Subject: A/3/21/PL - Further Engineers Comments Regarding Surface Water Drainage

Further Engineers Comments Regarding Surface Water Drainage

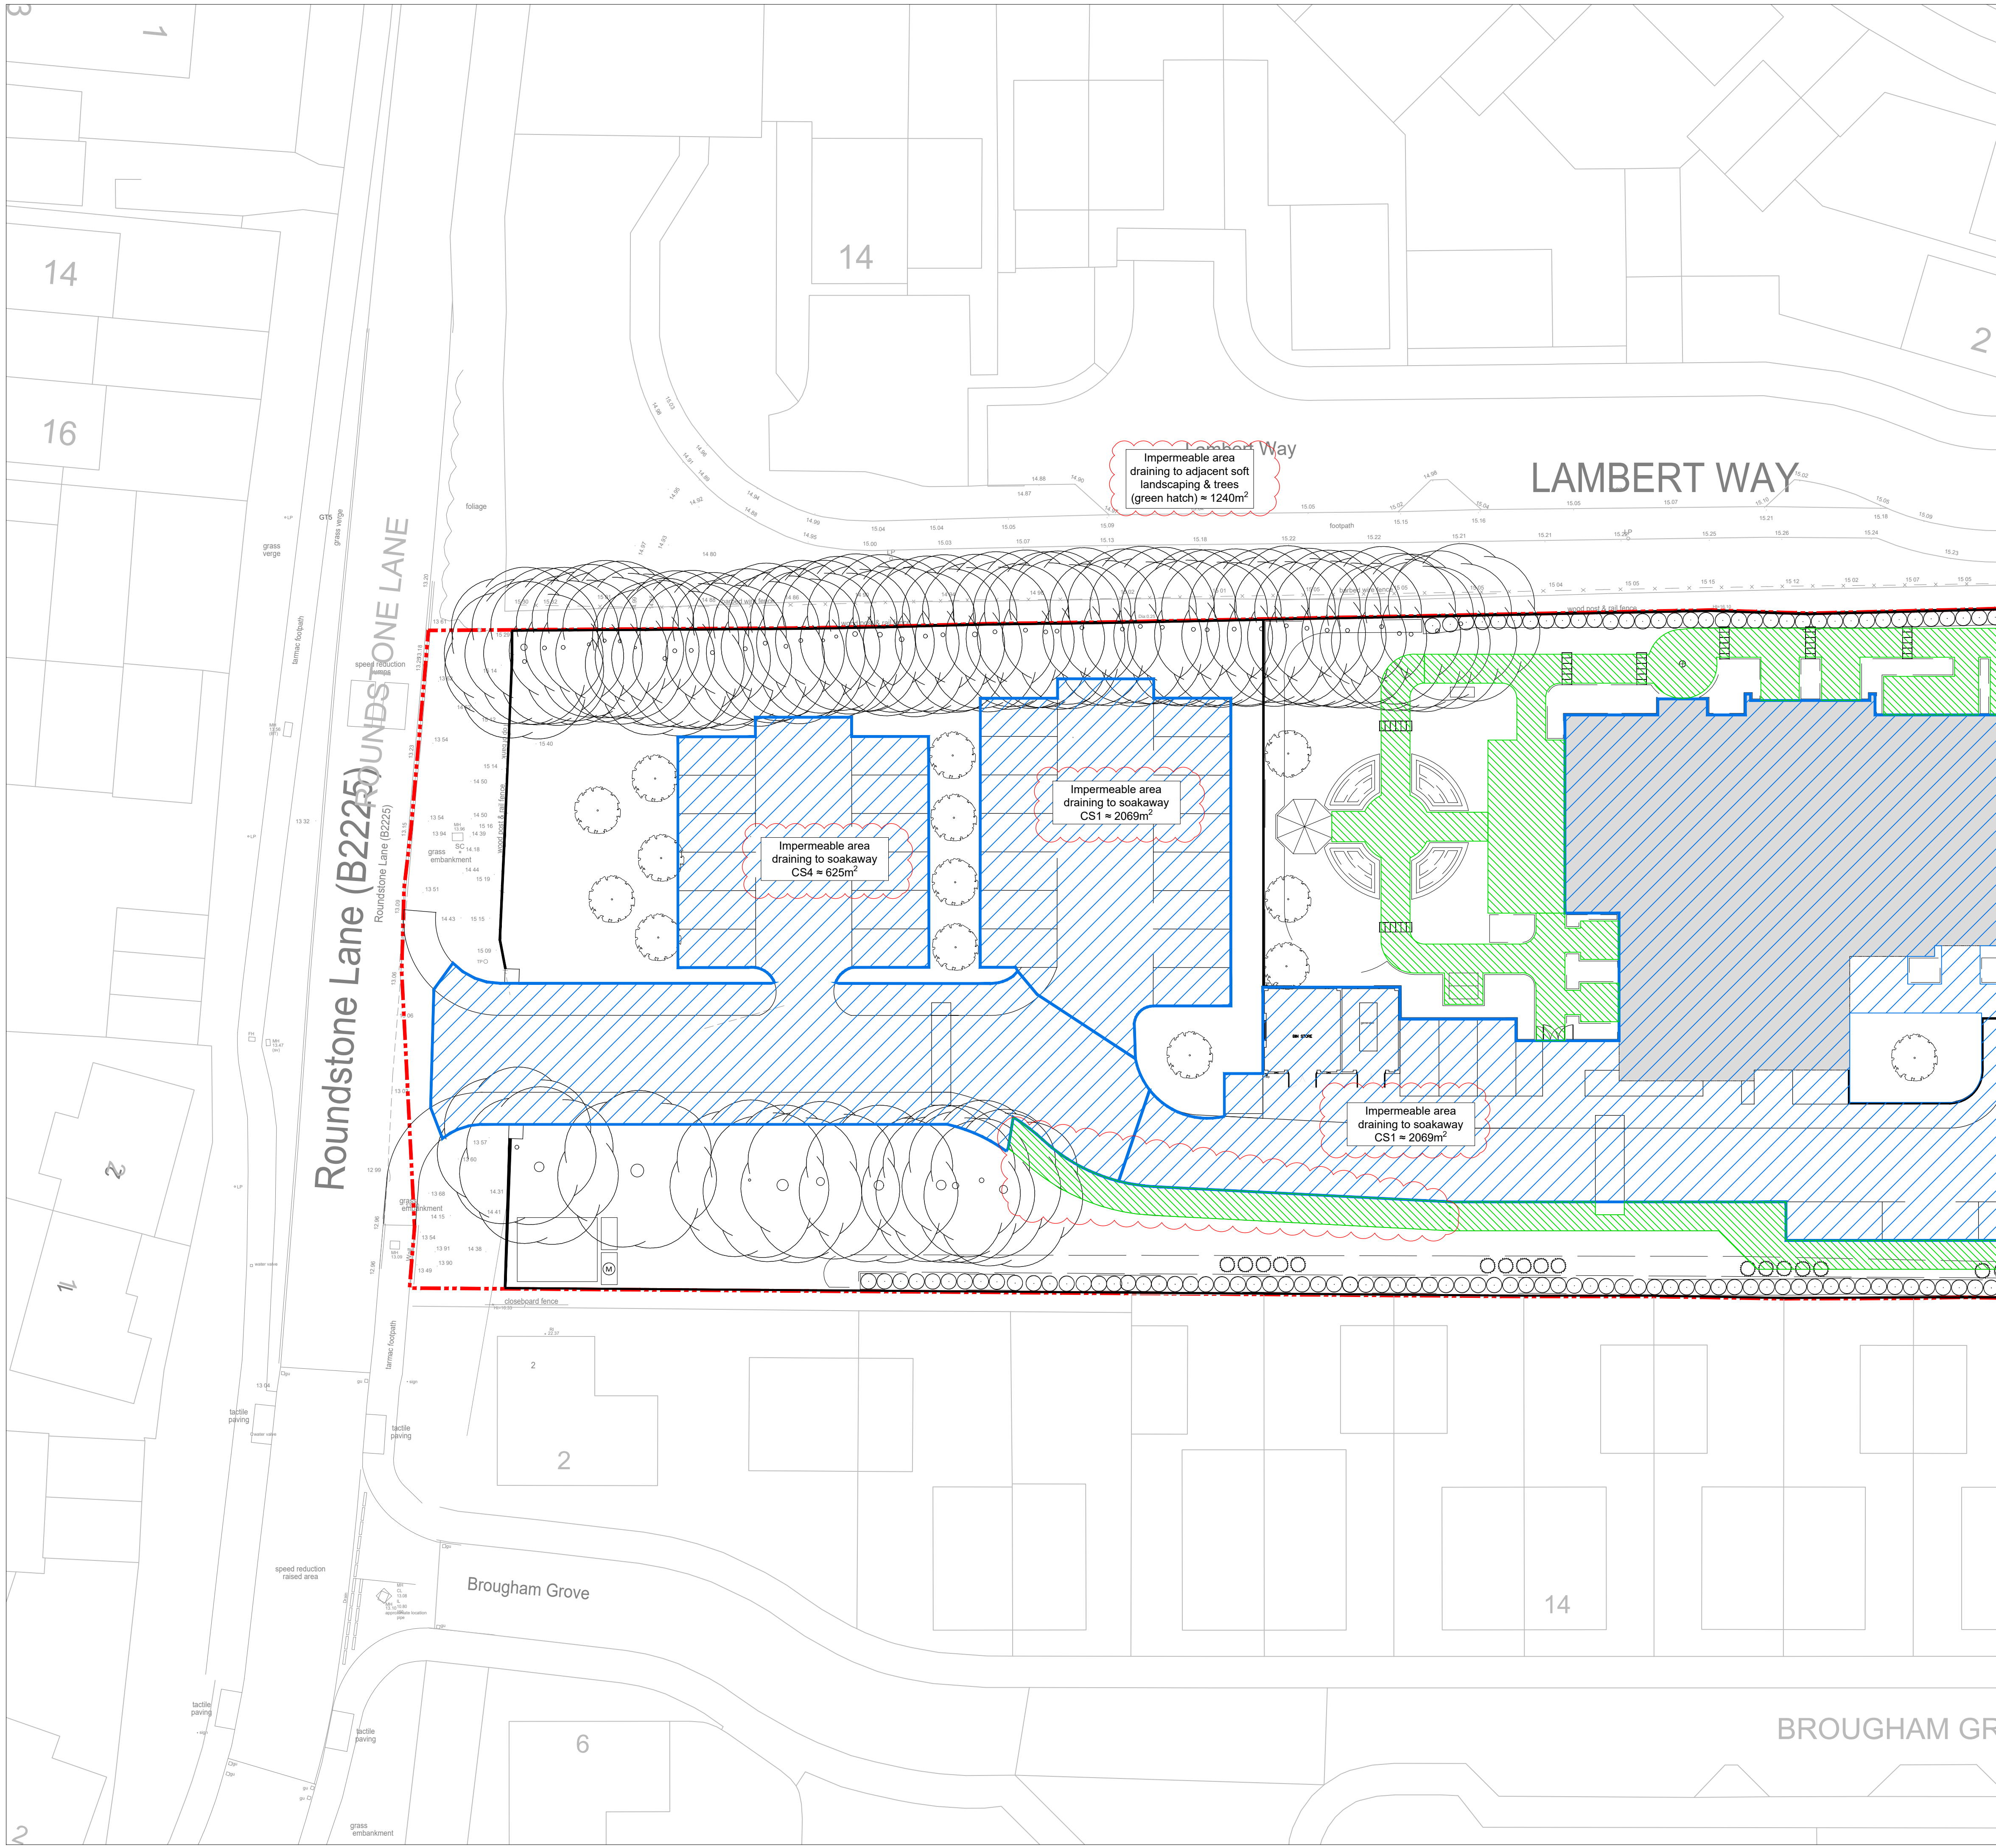
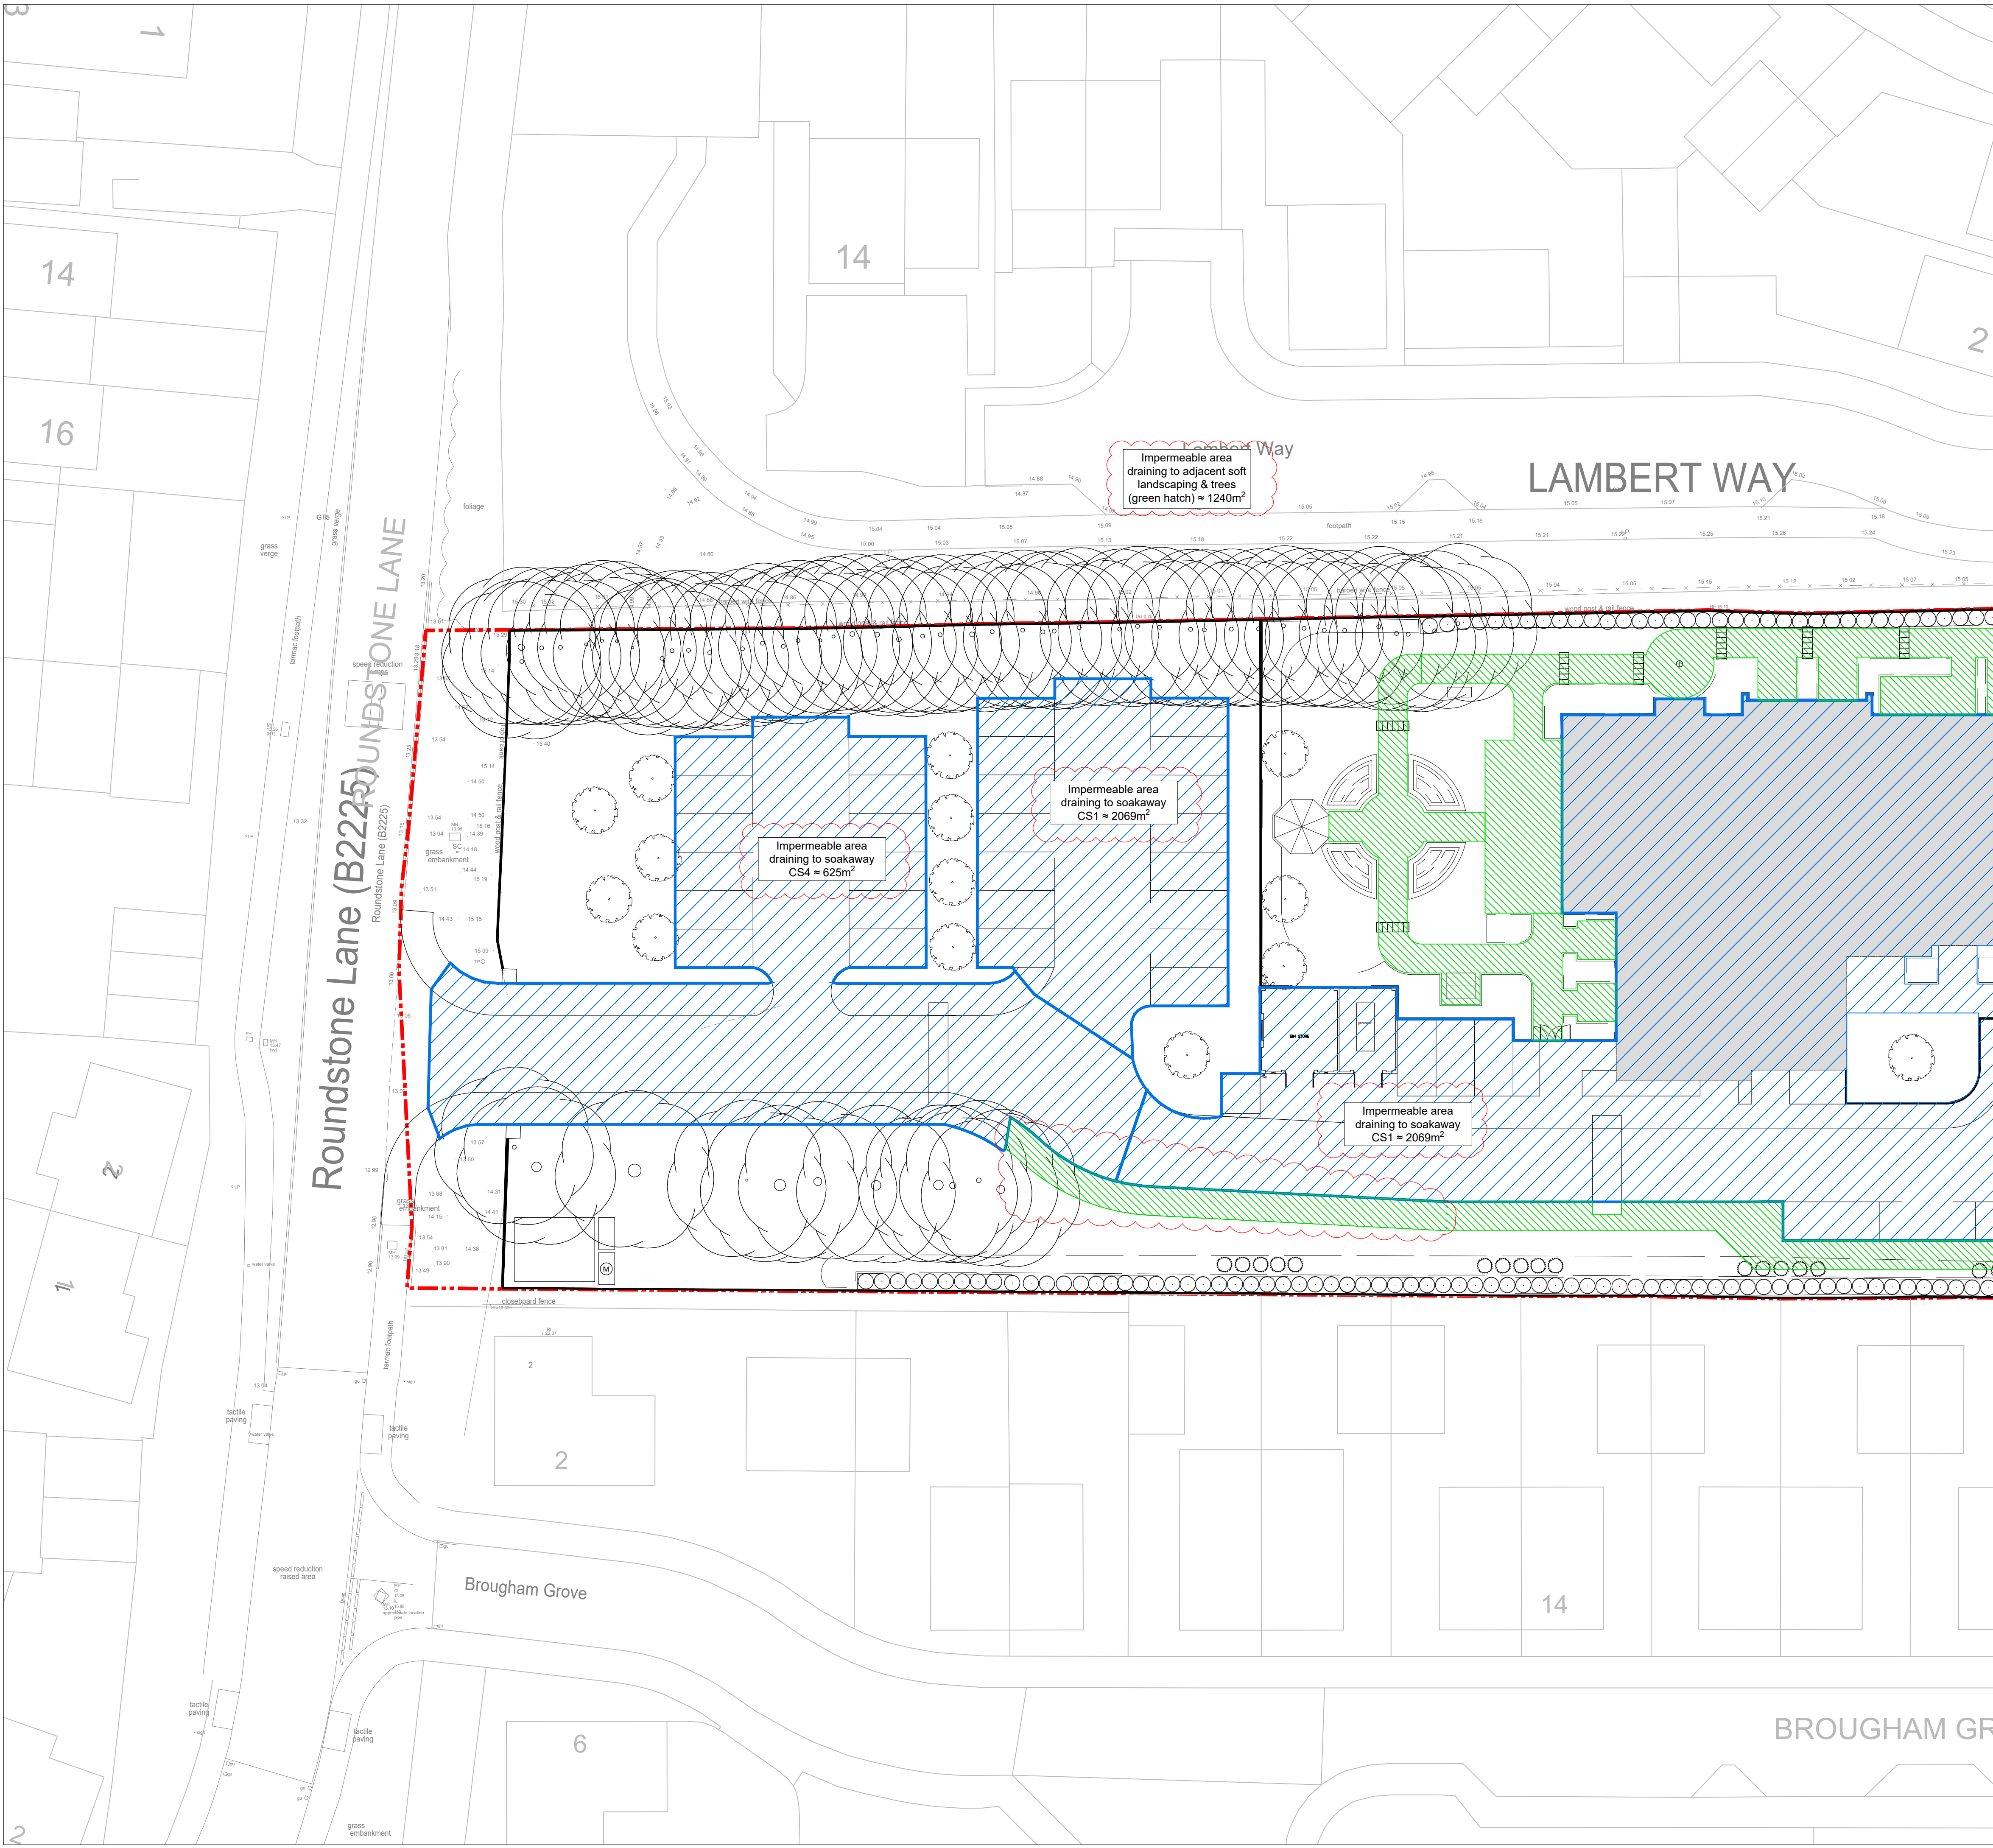
On the basis of the above, if you are minded to approve this application, please ensure that the Surface Water Drainage is constructed in accordance with the following plans:

Proposed Drainage Layout 64 Bed Sheet 1 3011 C06
Proposed Drainage Layout 64 Bed Sheet 2 3012 C07
Proposed Drainage Layout 64 Bed Sheet 3 3013 C07
Proposed Impermeable Areas Sheet 1 3500 P03
Proposed Impermeable Areas Sheet 2 3501 P03
Proposed Foul Water Manhole Schedule 3100 C05
